Sent: 12 January 2012 11:22
To: Planning
Subject: Planning application S6/2011/2685/FP - Land adjoining 29 & 30 Greenfields

District ref: S6/2011/2685/FP
HCC ref: WH/382/2011
HCC received: 22/12/2011
Area manager: James Dale
Case officer: Lindsey Lucas

Land adjoining 29 & 30 Greenfields
South Drive,
Cuffley

Erection of two bungalows

SITE PLAN - scale 1:200

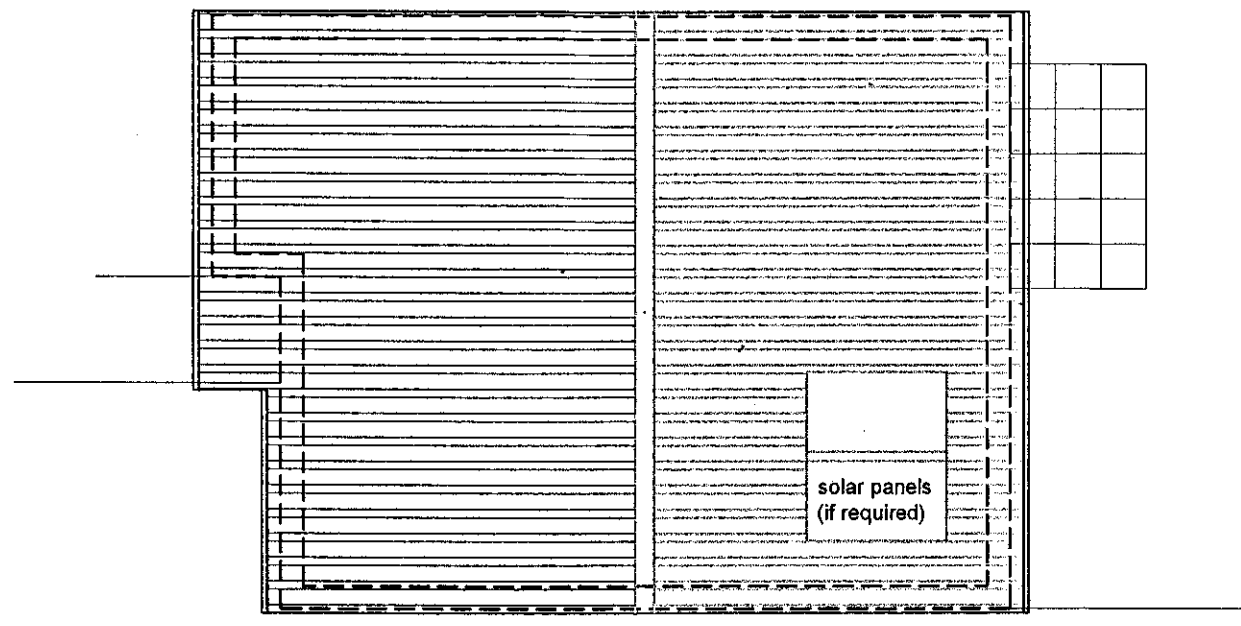
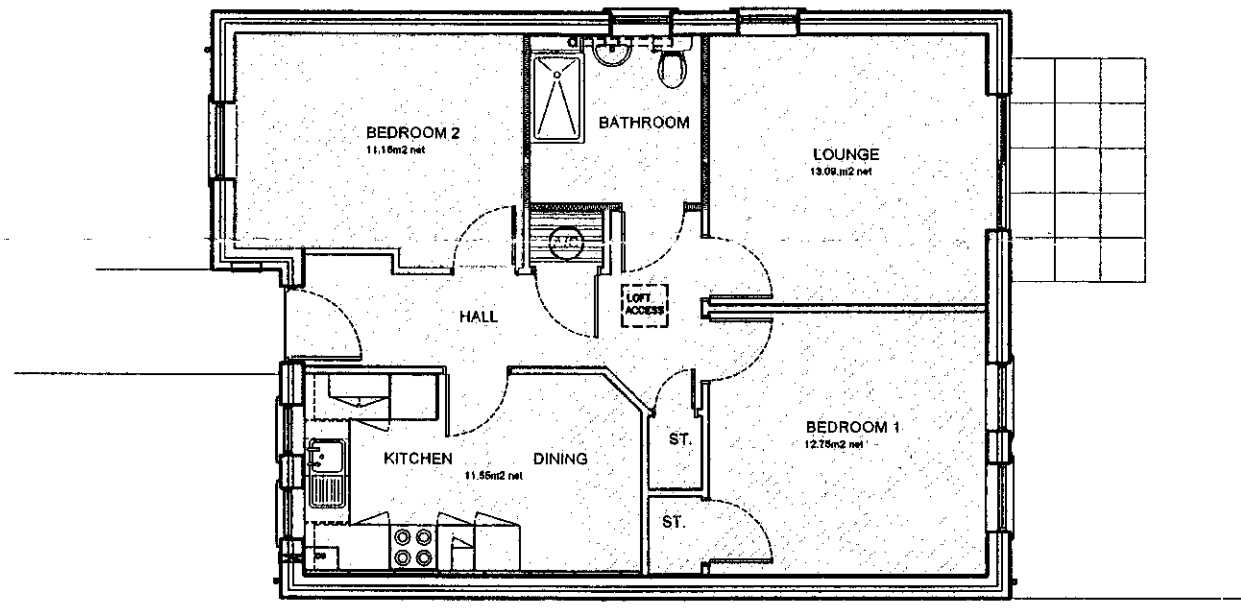
1. Prior to first occupation of the development the associated car parking shown on approved plan 12021/001 shall be laid out and used for no other purposes. Reason: To ensure the development makes adequate provision for the off-street parking and manoeuvring of vehicles likely to be associated with its use.

COMMENTS: This application is for two dwellings and three new parking spaces which would be accessed from the southern end of South Drive. South Drive is a local access road and it is proposed that the existing kerb would be removed to provide access to the three parking spaces.

It should be noted that the footway at the southern end of the road is not part of the public highway, whereas the carriageway is. To provide the access to the proposed parking spaces a new crossover will be required from the carriageway and the applicant will need to discuss the procedure for carrying out this work with Mid West Hertfordshire Highways Area Office (Telephone 01727 816000).
